Item No. **Report of the Head of Development Management and Building Control**

Address: 37 FAIRHOLME CRESCENT HAYES

Development: Retention of single storey rear extension (Retrospective application).

LBH Ref Nos: 20685/APP/2023/2201

PROPOSED GROUND FLOOR PLAN

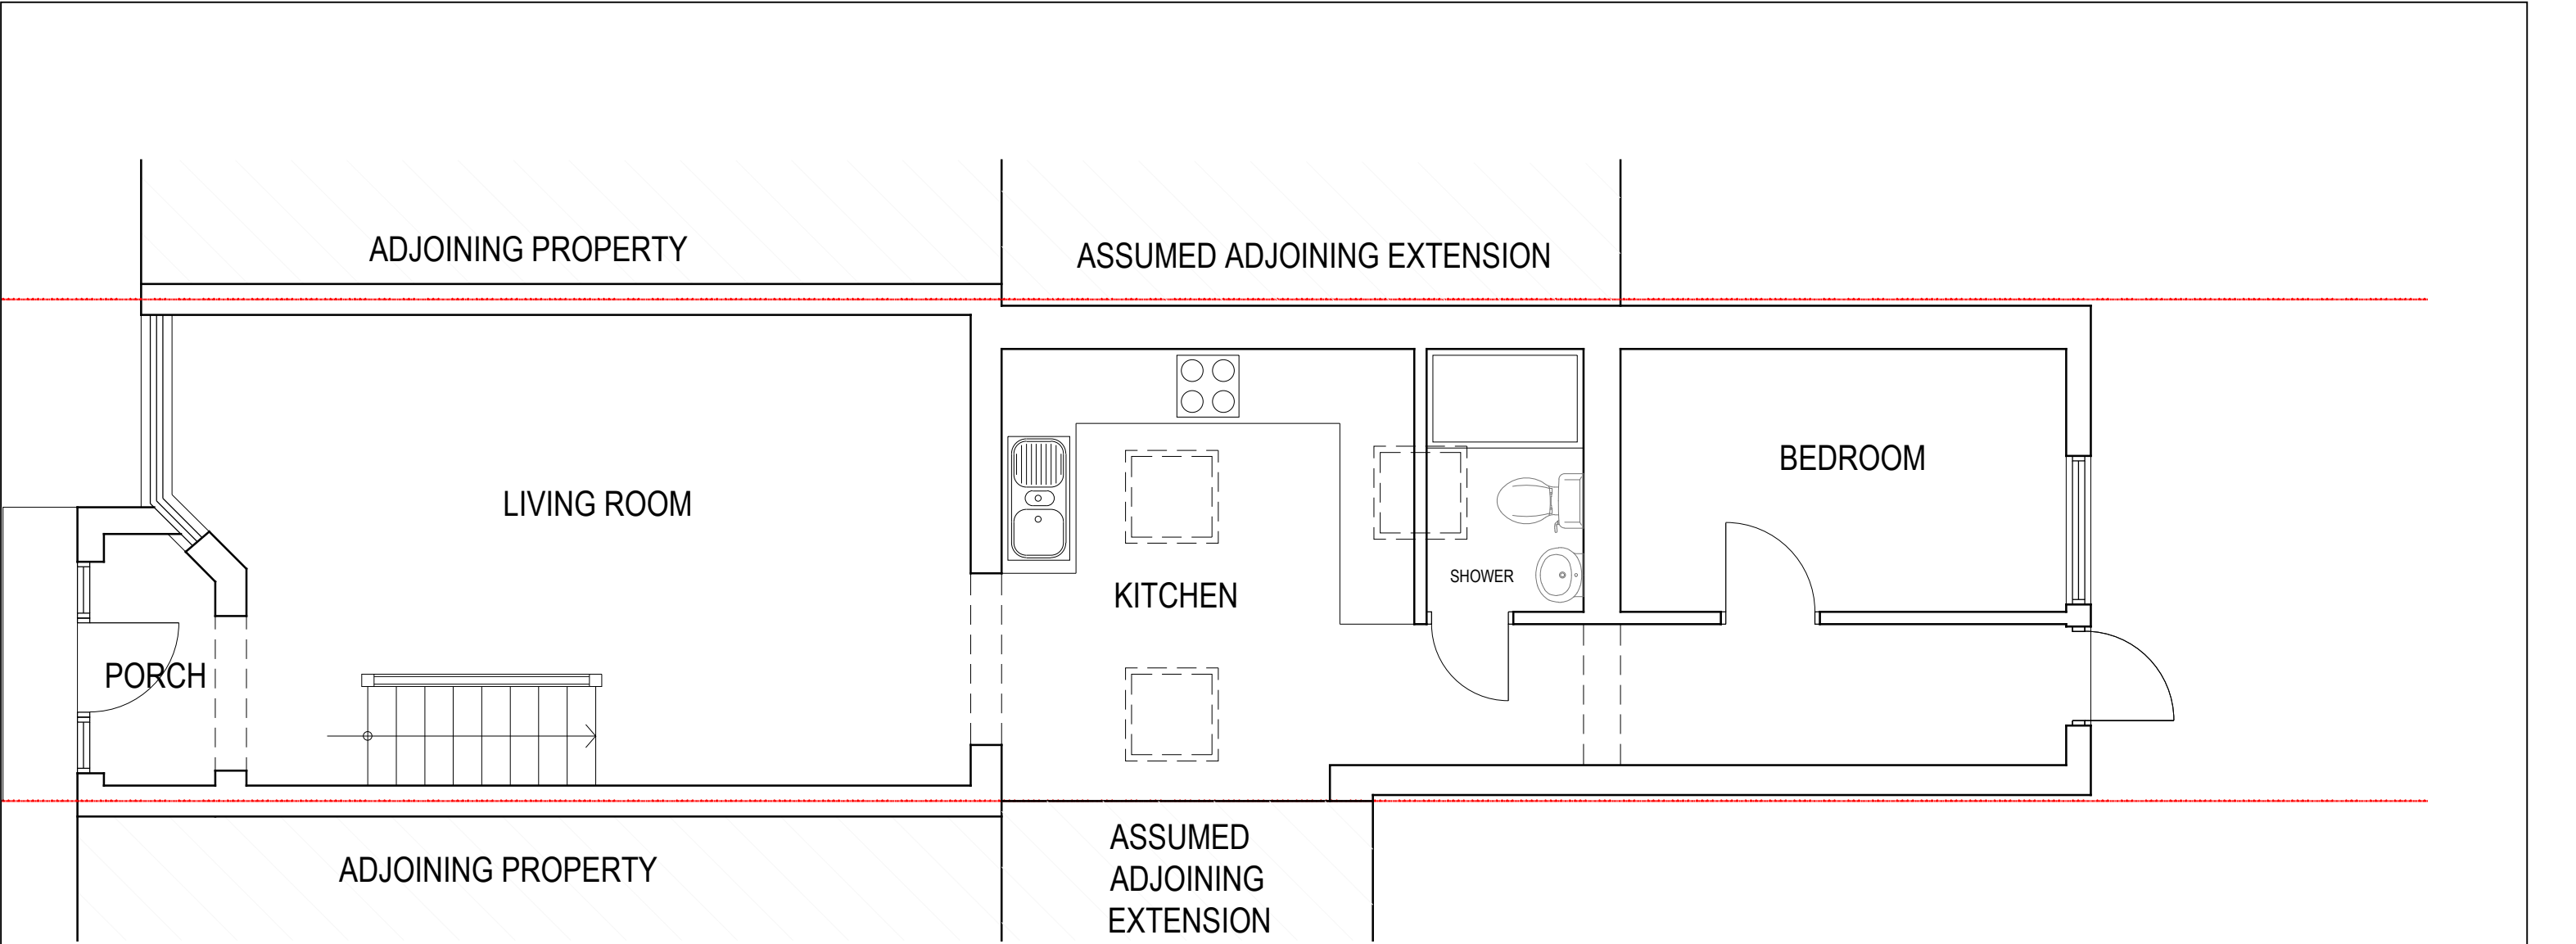
The retrospective development consists of a single storey rear extension which has been attached to an existing extension at the property. The cumulative extension measures 8.8m deep and varies from 2.6 to 2.9m in height. It is noted that the previous single storey rear extension does not appear to have planning permission.

The retrospective extension which planning permission is sought for would result in a cumulative extension which is significantly over the depth allowed under Policy DMHD 1. Due to its excessive depth and bulk the extension has caused harm to the original dwelling house by substantially increasing its original footprint and forming a visually disproportionate addition.

No.39 Fairholme Crescent is located north of the application site and forms part of the row of terraced properties. The property does benefit from a small single storey rear extension. The retrospective extension constructed at the development site projects approx 5.80m deeper than the rear building line of this neighbour. Due to its combined height and depth the extension has caused overshadowing and a significant loss of light to the habitable rooms within this neighbouring property. Due to the depth of the extension, it would appear as over dominant and overbearing to this neighbour. It has also caused a unacceptable enclosing impact.

As such, the proposal, would cause unacceptable loss of light, overshadowing and be overbearing to the adjoining neighbour no.39 Fairholme Crescent. Therefore the proposal would not comply with Policies DMHD 1 and DMHB 11 of the Hillingdon Local Plan: Part Two - Development Management Policies (2020).
